DEVELOPMENT REVIEW BOARD
TRANSPORTATION DEVELOPMENT

DRB Project Number: 1011471
Mcleod Business Park

SUBJECT: Preliminary/ Final Plat

Application #: 18DRB-70127

**Plat for
Tracts 2-A-3-C-1 & 2-A-3-C-2
McLeod Business Park
Being Comprised of
Tracts 2-A-3-C and 2-A-3-D
McLeod Business Park
City of Albuquerque
Bernalillo County, New Mexico
March 2018**

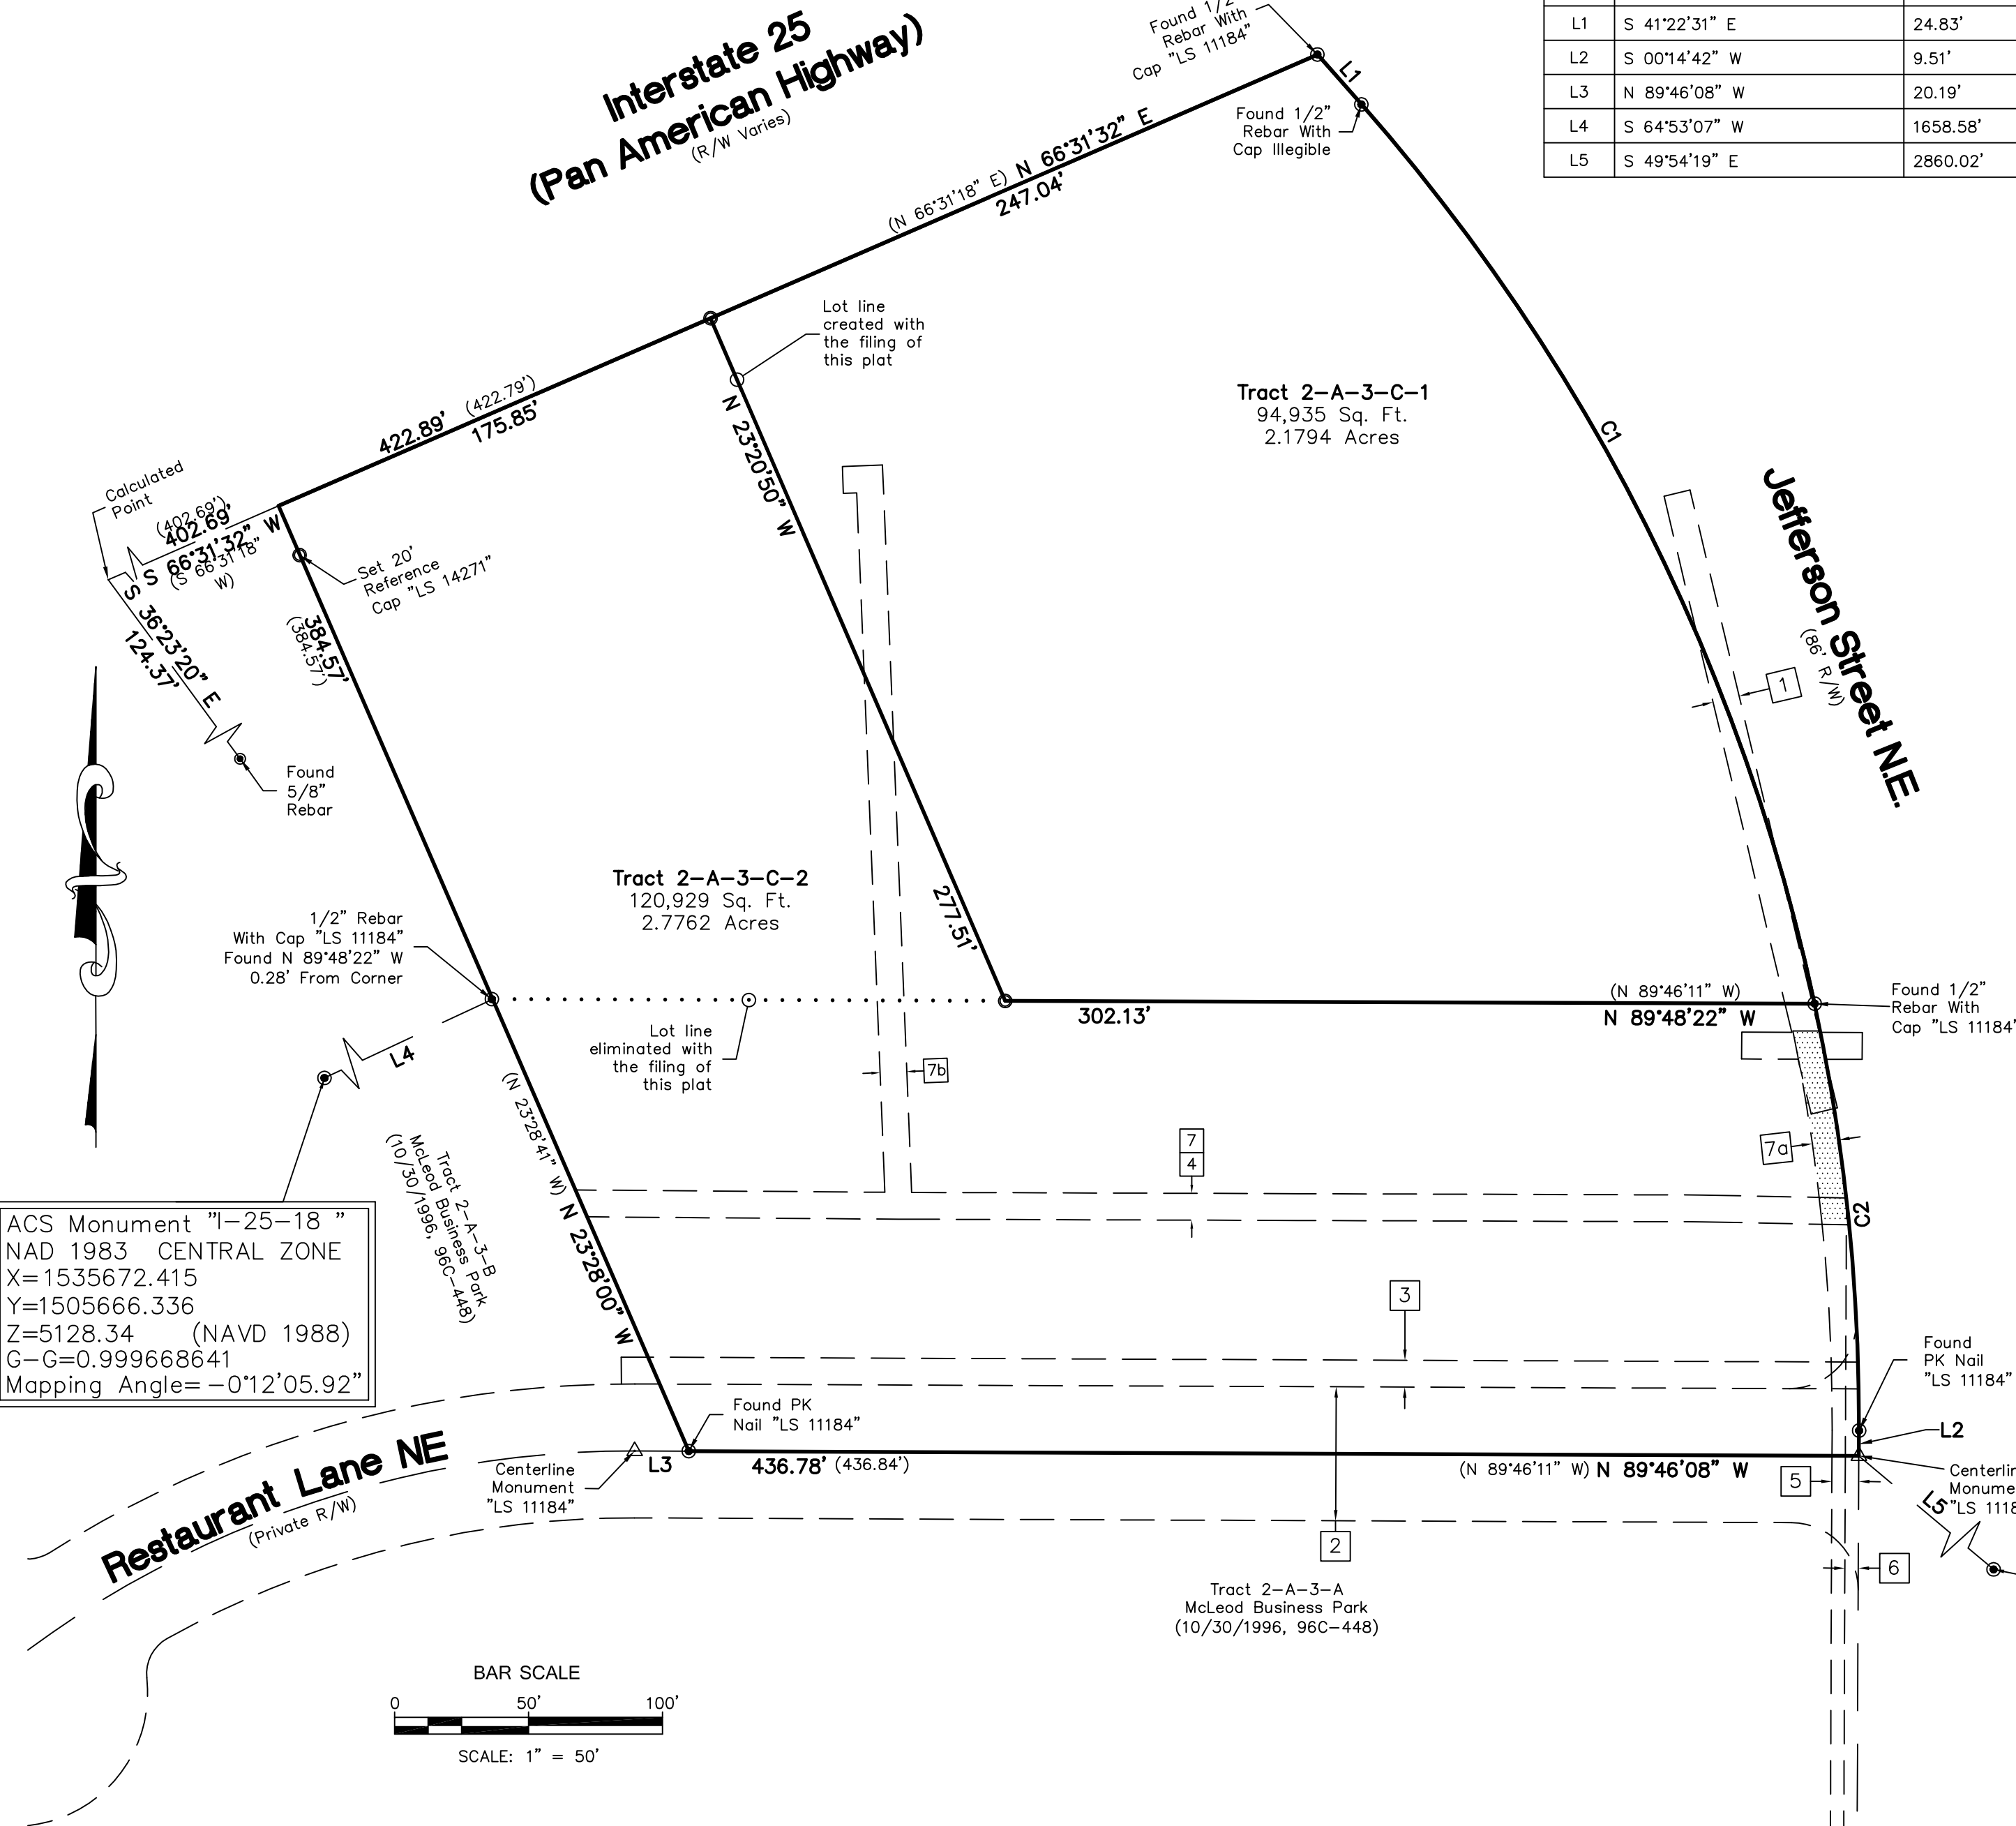
1. Provide a shared access and parking easement between the lots.
2. For final plat, any access easements need to be shown with all beneficiaries and maintenance responsibilities listed.
3. If future development is not going to be submitted to DRB, a TCL (Traffic Circulation Layout) will be required before building permit.
